Ribble Valley Borough Council
By email

Your ref 3/2025/0801
Our ref DC/25/3013
Date 19-MAY-26

Location: Land to east of Salesbury View Wiltshire

Proposal: proposed erection of new residential development comprising 80 new homes, including 30% affordable housing, open space and associated infrastructure

Drawing file: planx_downloads / 25_0801_Amended_P12_Proposed_Site_Layout_Coloured_10apr25.pdf

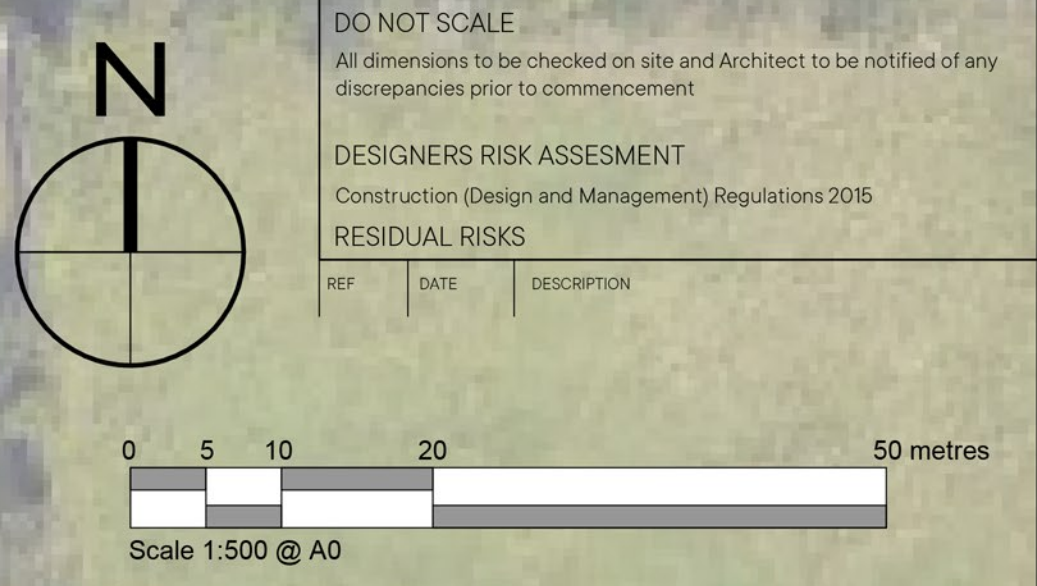
- The removal of permitted development rights in relation to properties 1, 2, 21, 22, 23, 24, 25, 45, 46, 47, 48, 49, 50 and 51 as shown in document reference Proposed Site Layout, Drawing No 101, Revision P25 dated July 2023
- The inclusion of the below pre-commencement asset protection condition to ensure sufficient protective measures are provided for our large diameter trunk main which is located within the site boundary
- Clarification regarding proposed steps within the easement width

Project No. 210687	PRELIMINARY NOT FOR CONSTRUCTION
Drawing No. 210687-EDGE-XX-XX-DR-C-1094	
Revision	
P08

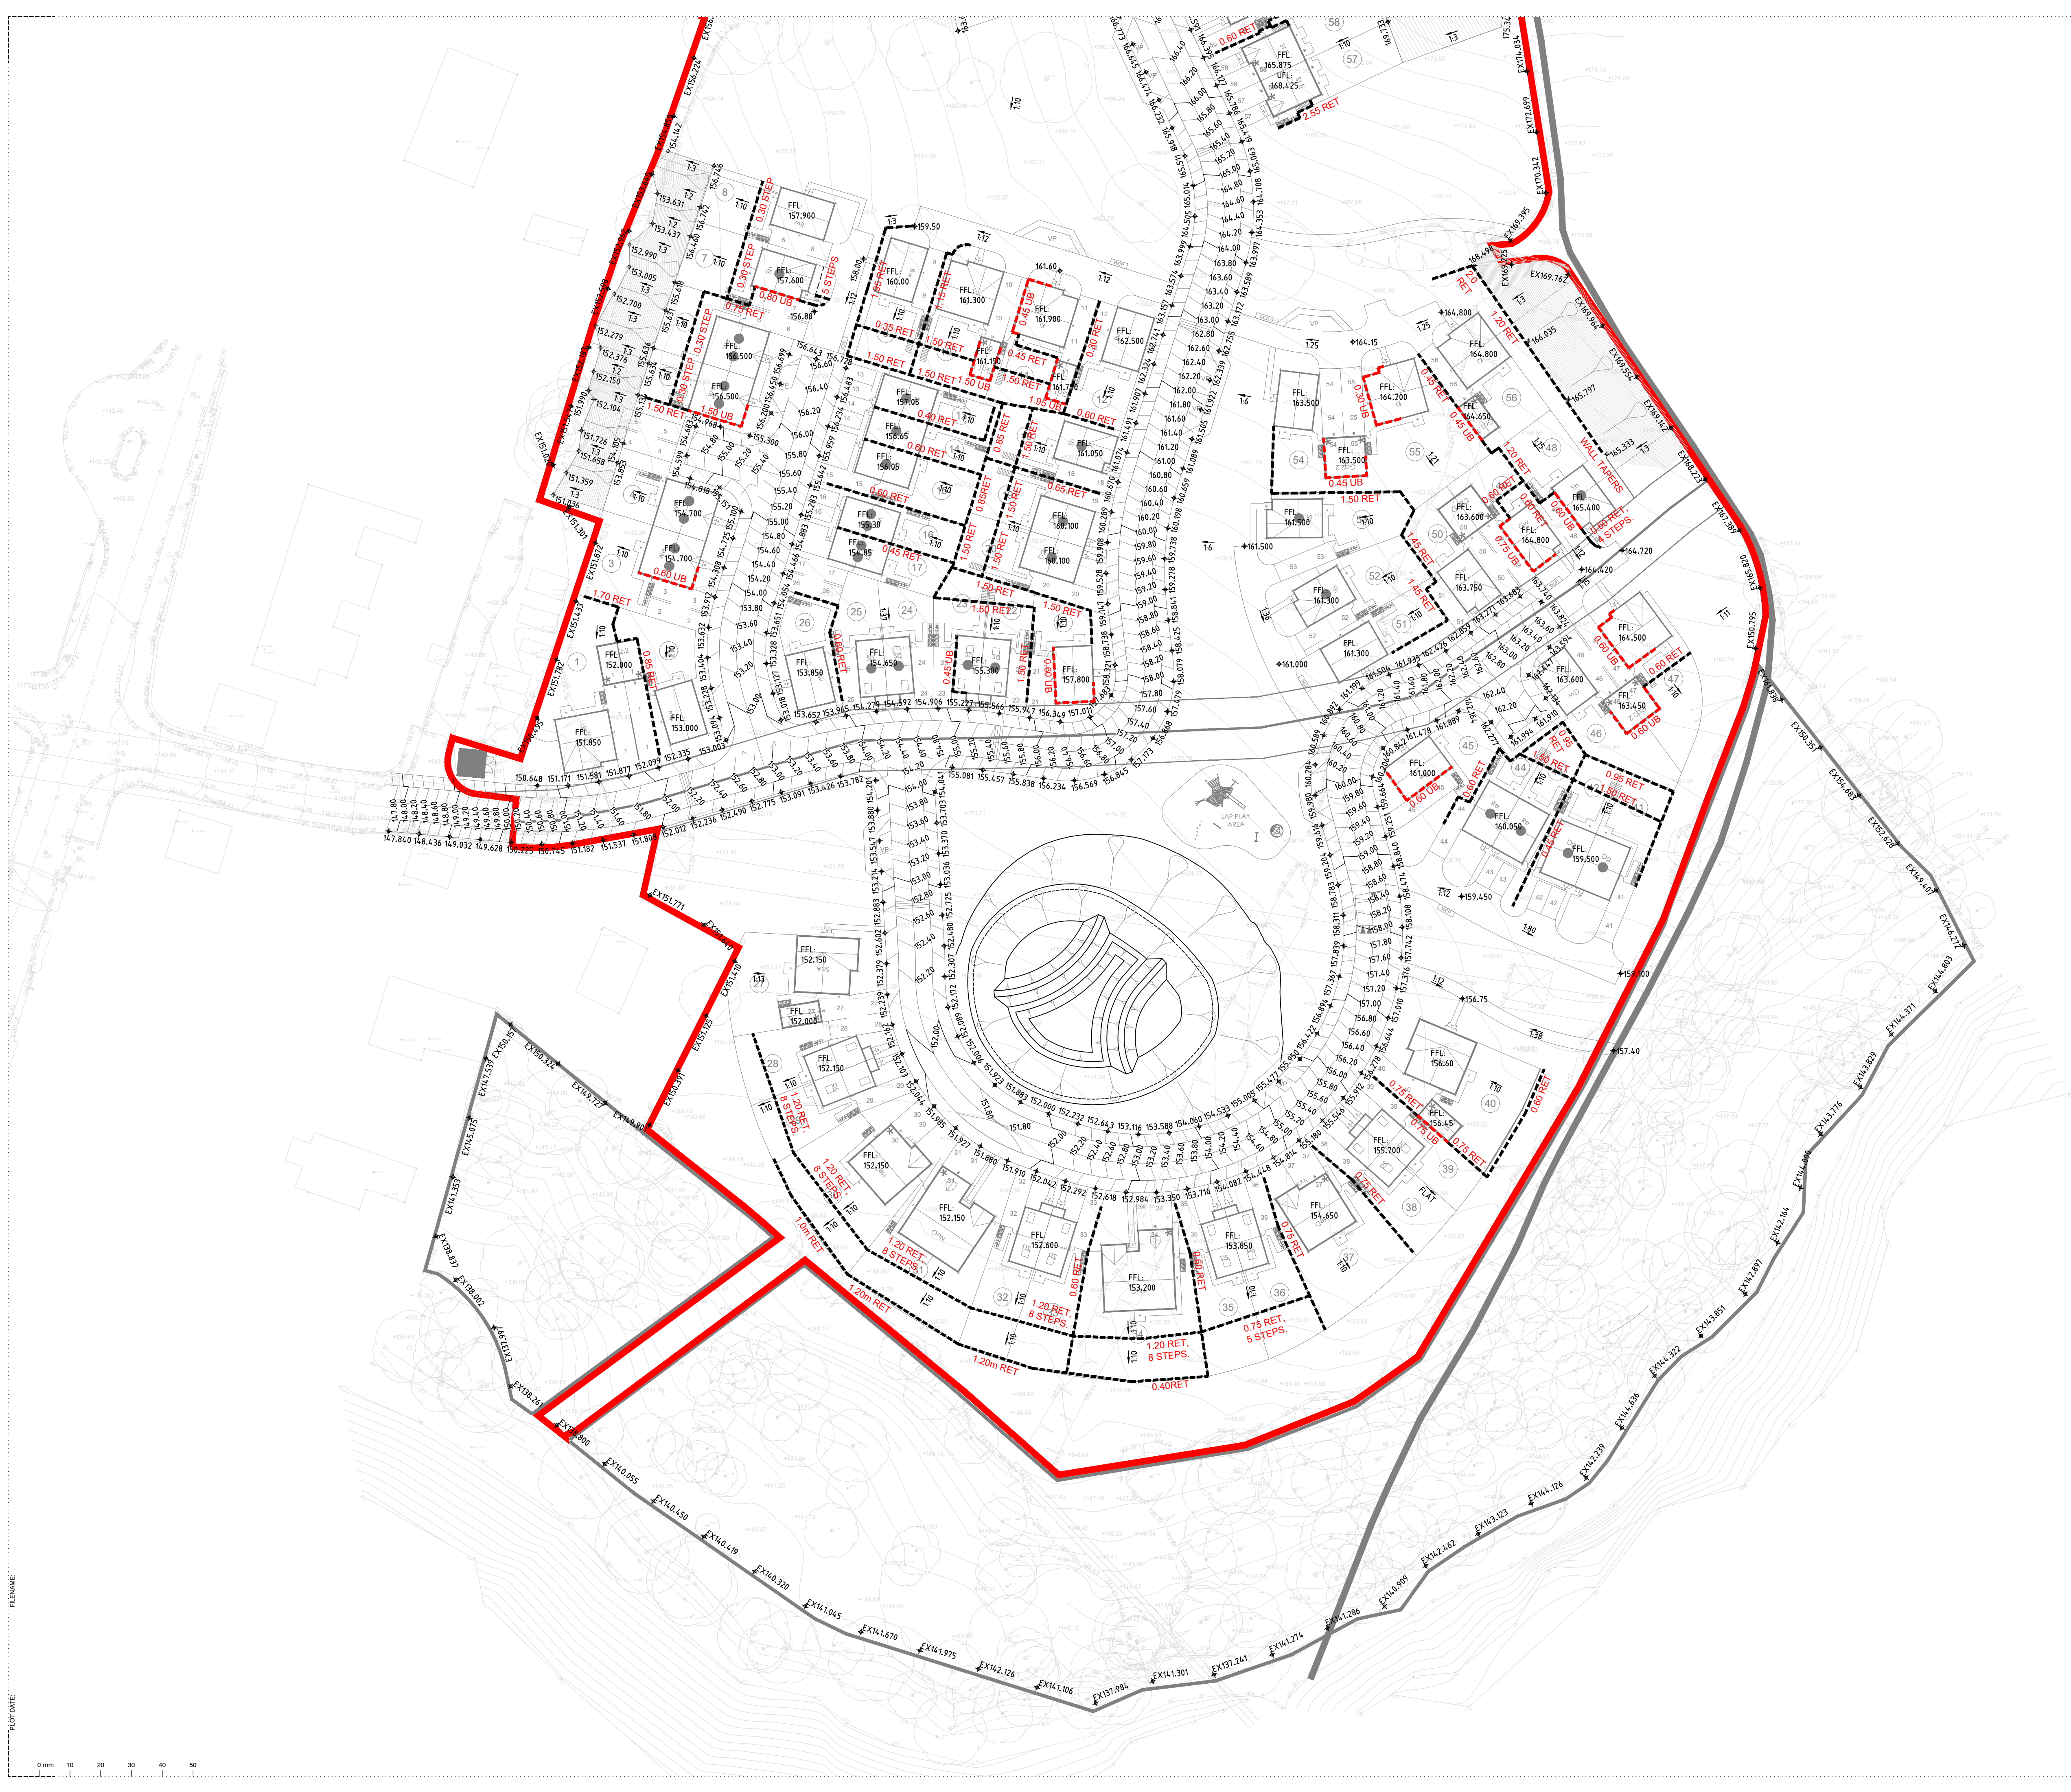
It does not yet appear that sectional drawings showing the proposed clearance between the water main on site and the proposed drainage has been submitted. Additionally, the Finished Floor Levels are 150mm or less from the drainage cover levels. Given the gradient of the site, if 150mm of clearance cannot be achieved then we would expect updated flood exceedance paths to be submitted
